SUBJECT: Triangle Expressway Southeast Extension (Complete 540) from NC 55 Bypass in Apex to US 64/264 (I-87) in Knightdale, Wake and Johnston Counties; Federal Aid No. STP-0540(19), STP-0540(20), and STP-0540(21); WBS Nos. 37673.1.TA1, 35516.1.TA1, and 35517.1.TA1; STIP Project Nos. R-2721, R-2828, and R-2829

Action ID No. SAW-2009-02240; Complete 540; TIP R-2828

Also, please reference your April 16, 2021 letter, requesting modification of the permit (Mod 05) to authorize changes due to an impact evaluation error. Specifically, the excavation at Permit Site 44, impacting 0.02 acre of wetlands was previously shown as hand clearing impact.

**North Carolina Division of Water Resources  
Transportation Permitting Unit  
In-Field Minor 401 Water Quality Certification Modification**

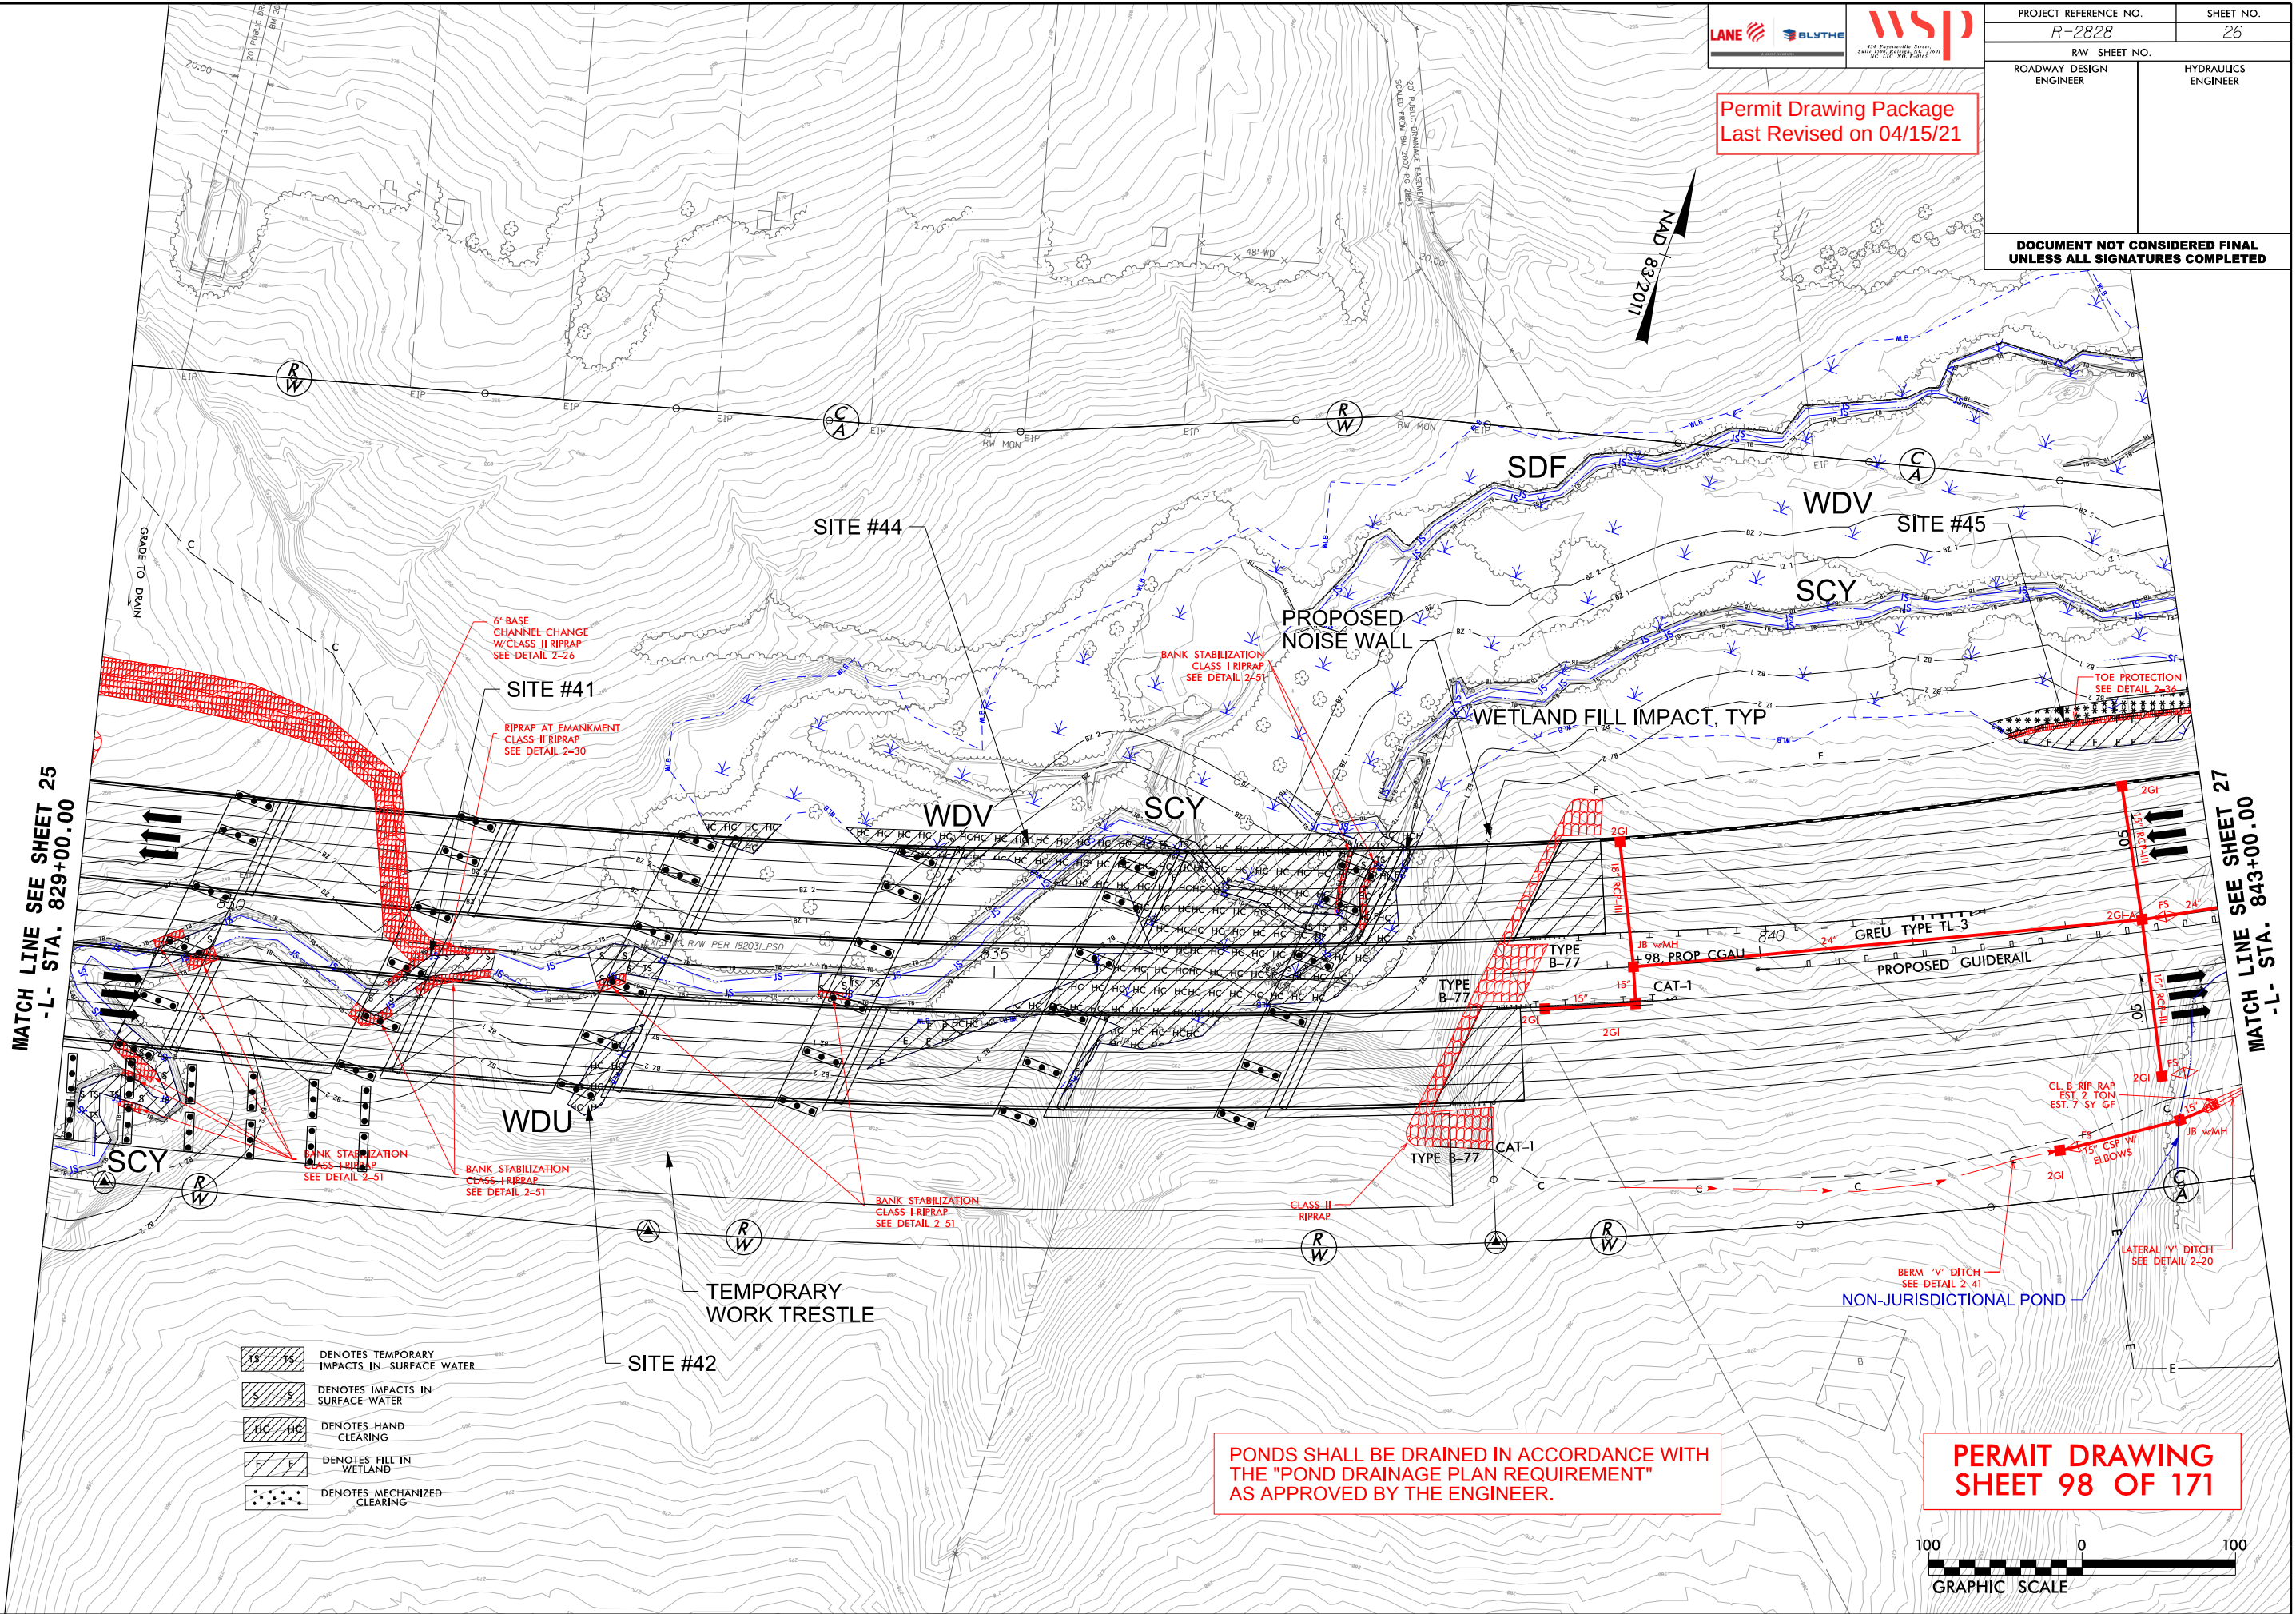
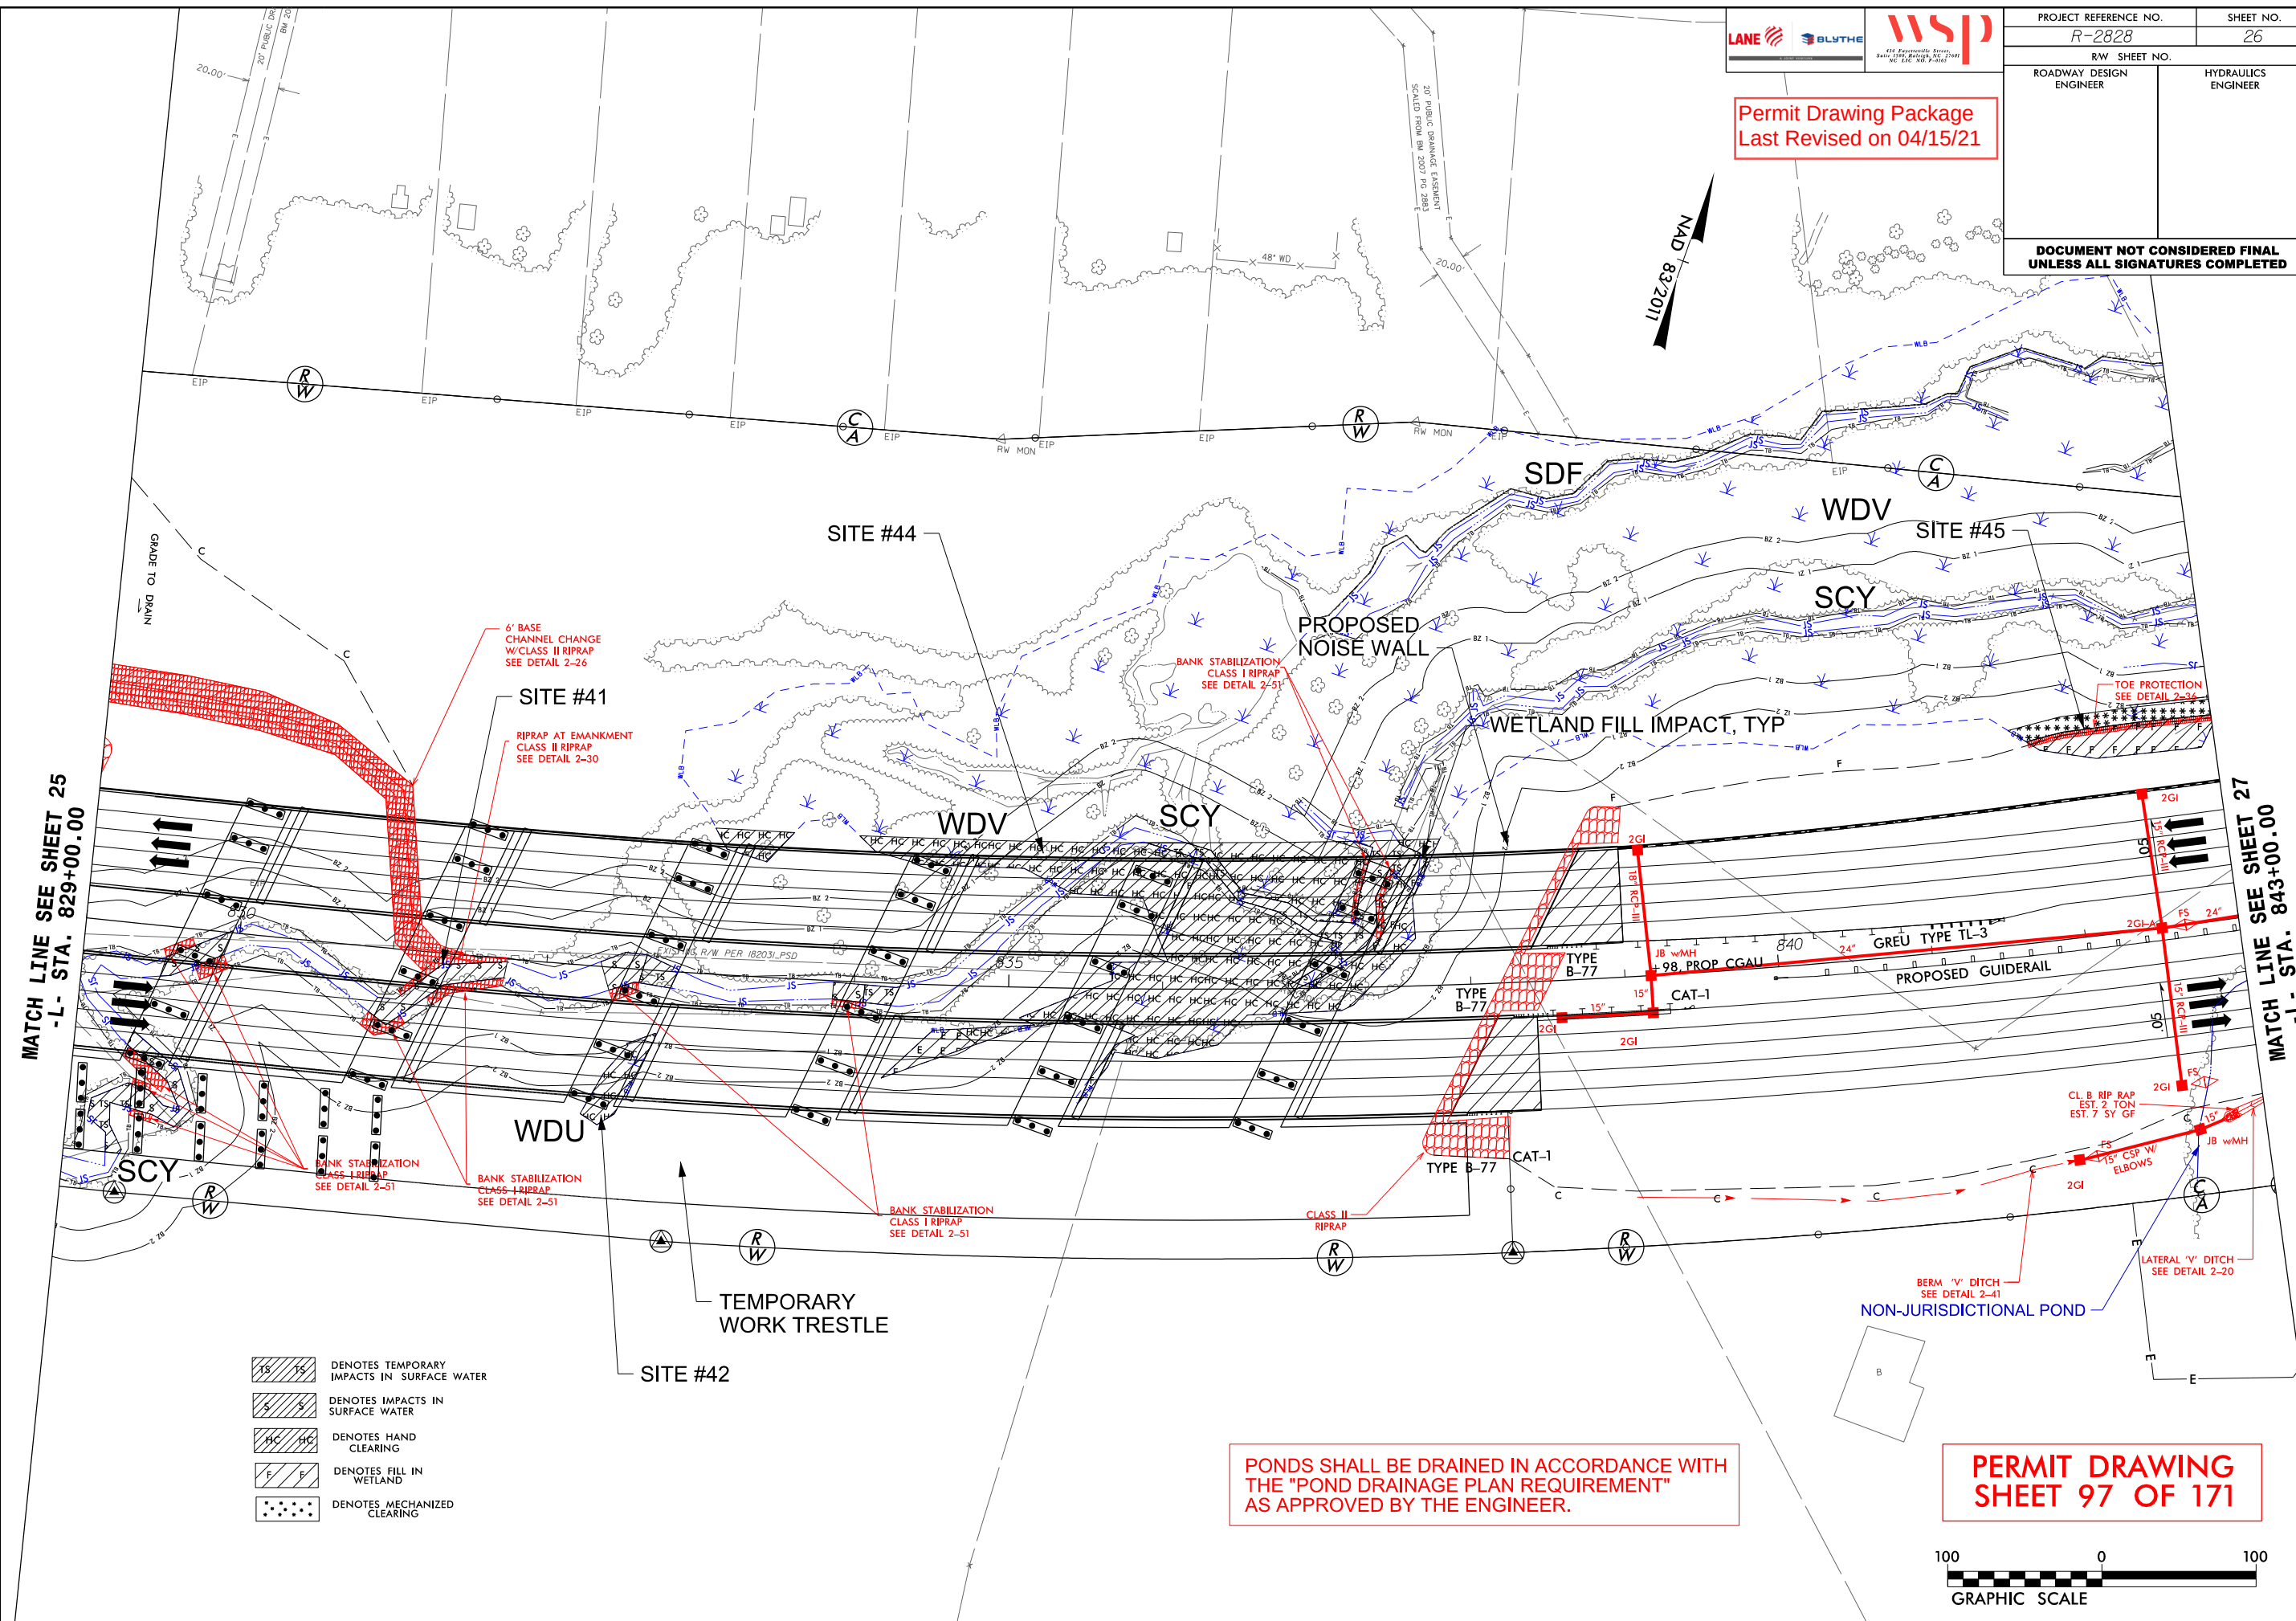
The Corps has completed the evaluation of your request and has determined that it is appropriate and reasonable, and no public notice is required for this modification. Therefore, the permit is modified as requested and as shown on the enclosed revised Permit Drawings, Sheets 1, 97, 98, 169, and 171 of 171, labeled "Permit Drawing Package Last Revised on 04/15/21."

**Site 44: 0.015 acres of Hand Clearing impact modified to Excavation impact.**

A small area of wetland under the bridge is at a higher elevation than bridge clearance allows. Instead of Hand Clearing, this area, aprox 0.015 acres must be Excavated down to level.

Change 0.015 acres of Hand Clearing impact to "Excavation" impact at Site 44 on project section R-2828.

Excavated area shall be seeded and/or mulched as necessary to maintain stability and prevent erosion.
